Application by Mallard Pass Solar Farm Limited for an Order Granting Development Consent for Mallard Pass Solar Project- EN010127

Submission by John Hughes: ID ref: 20036141

Deadline 2 Written Representation: Substation (APP- 125) & ZTV Figure 6.6 (APP-138), Representative View Points 1 – 20, APP-140 to APP-159, Photomontages A – E, APP 168 to APP – 172,

DRAWING TITLE
Figure 6.6: Zone of Theoretical Visibility (ZTV) Study, Representative Viewpoints and Illustrative Viewpoints

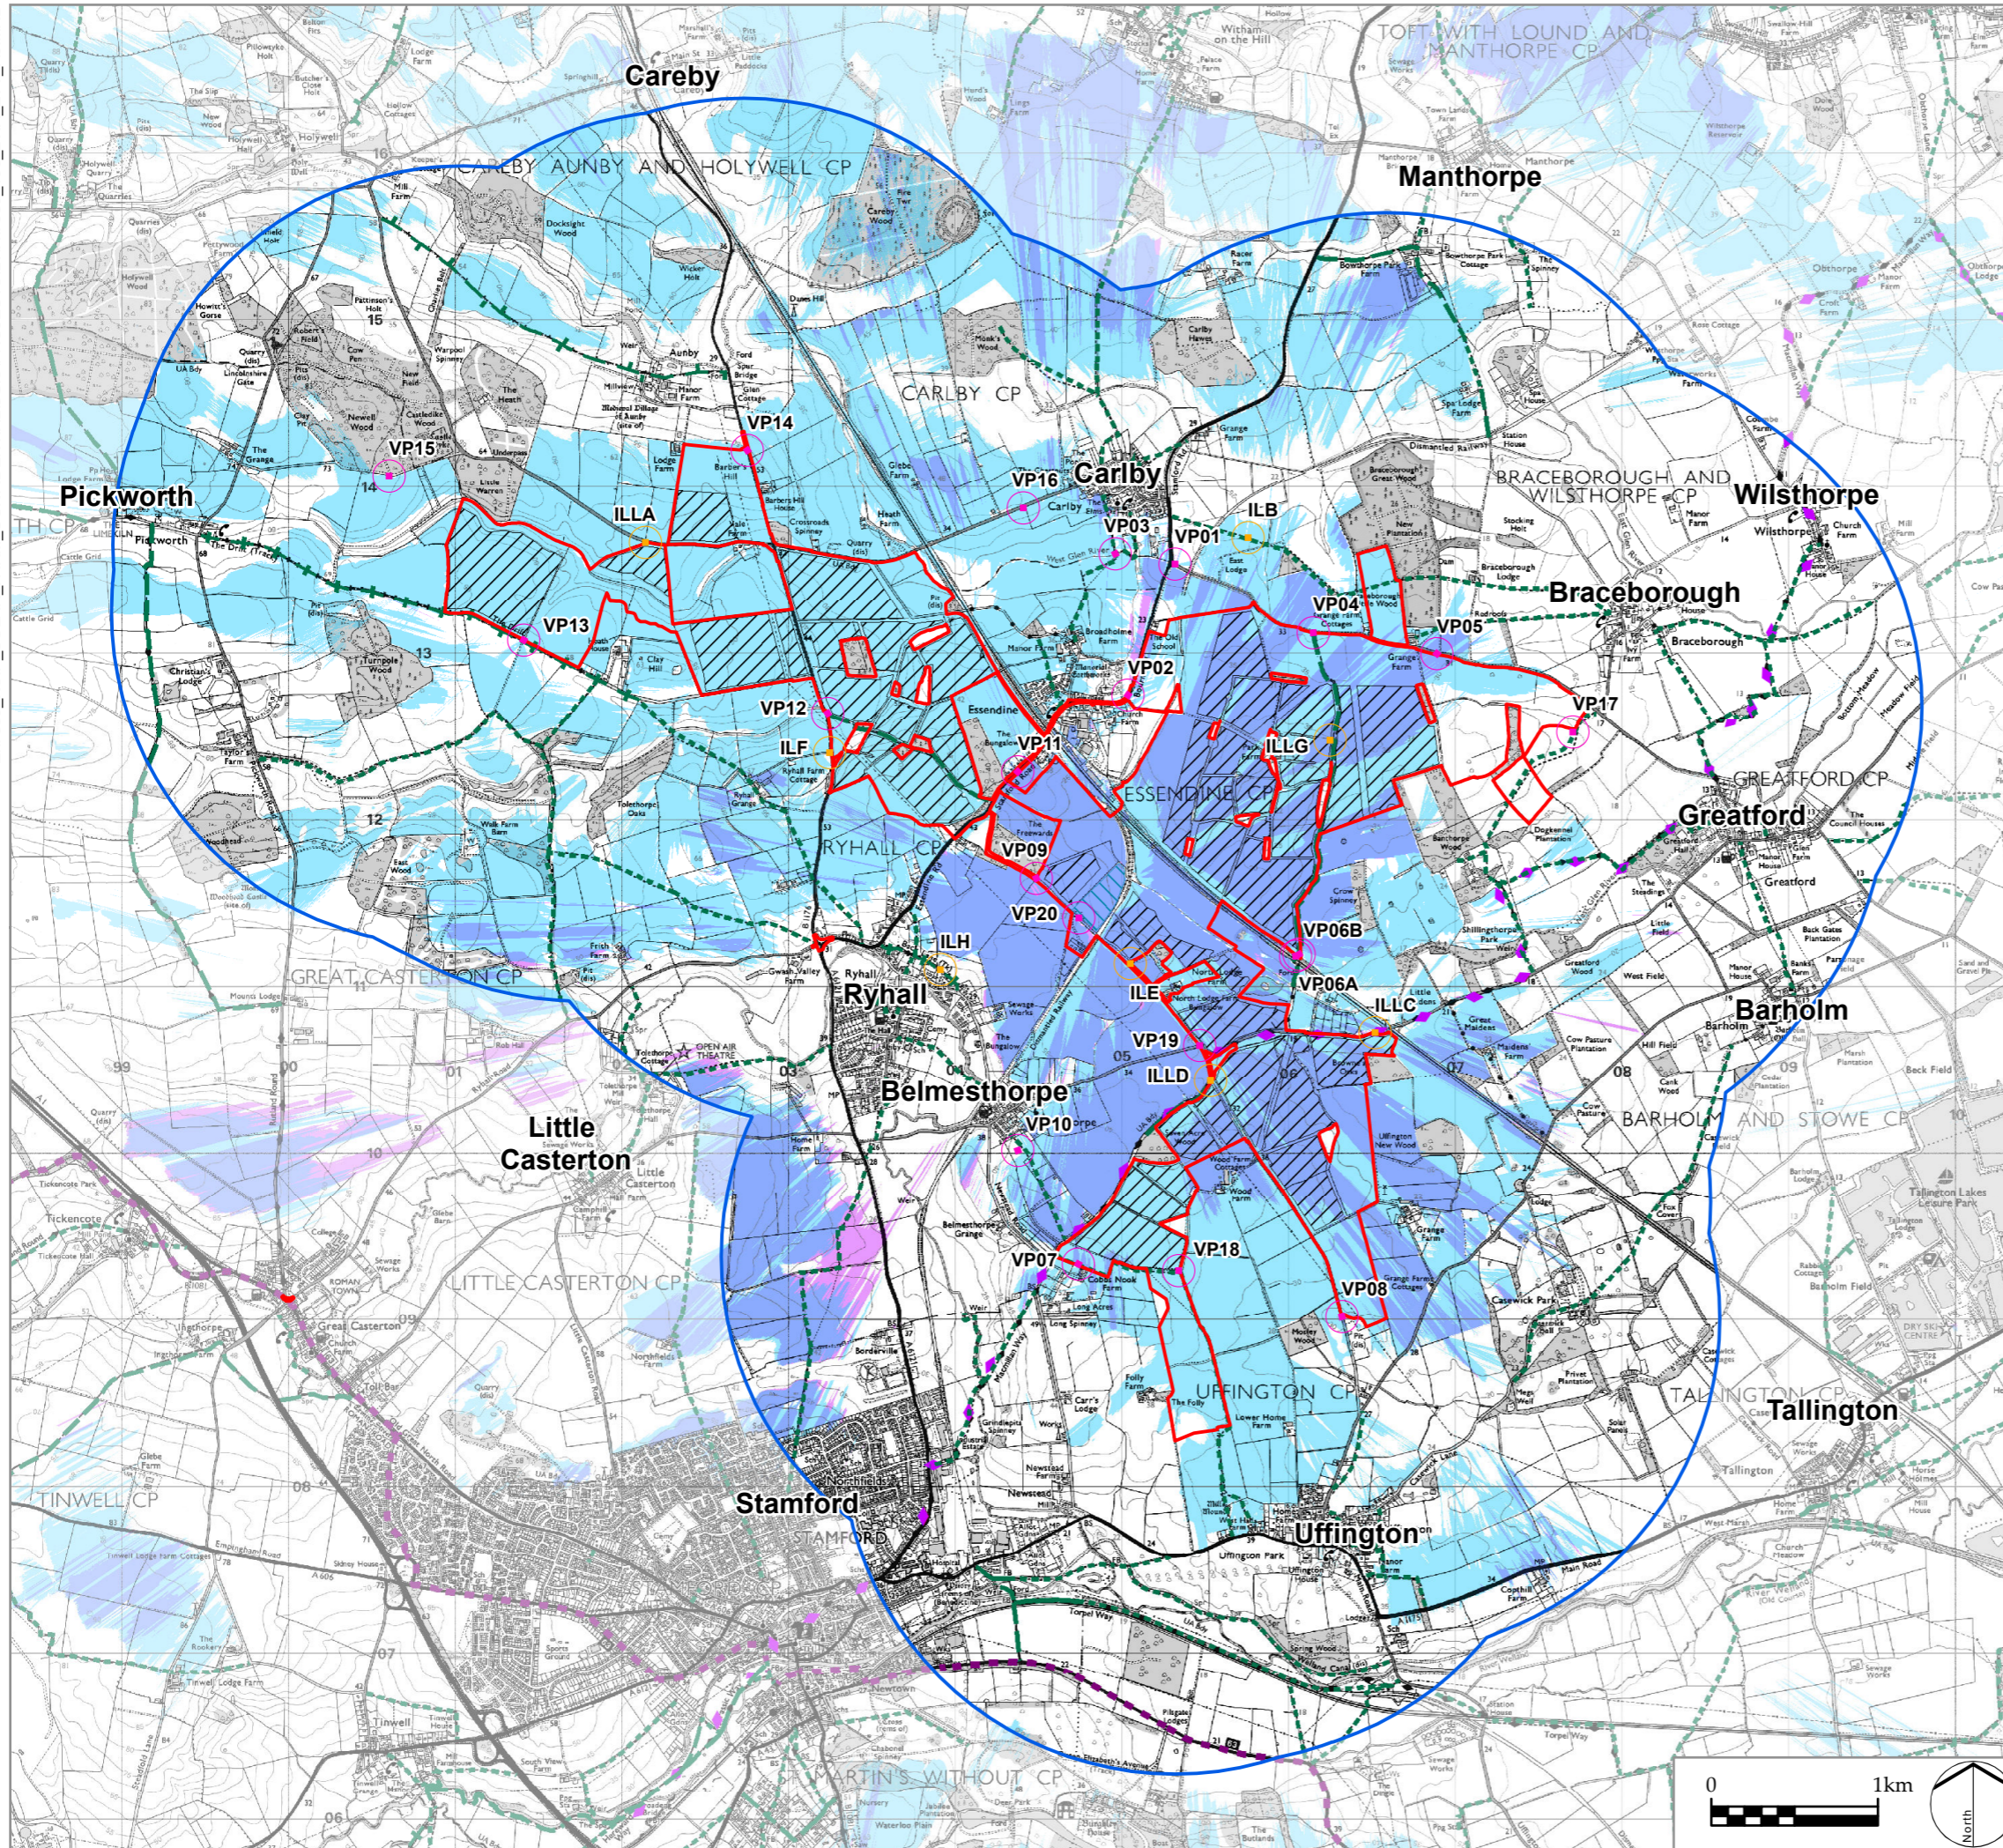
Pictures speak a thousand words and the viewpoint locations selected, photographs and photomontages presented in the DCO hide the magnitude of the impact this project will have and are totally bias in the applicants favour, misleading any viewer of the true scale of devastation the project will have on the local community. The examining authority should reject the DCO based on View Points, Photographs and Photomontages being bias in the applicants favour, lacking in detail and not representative of the true landscape.
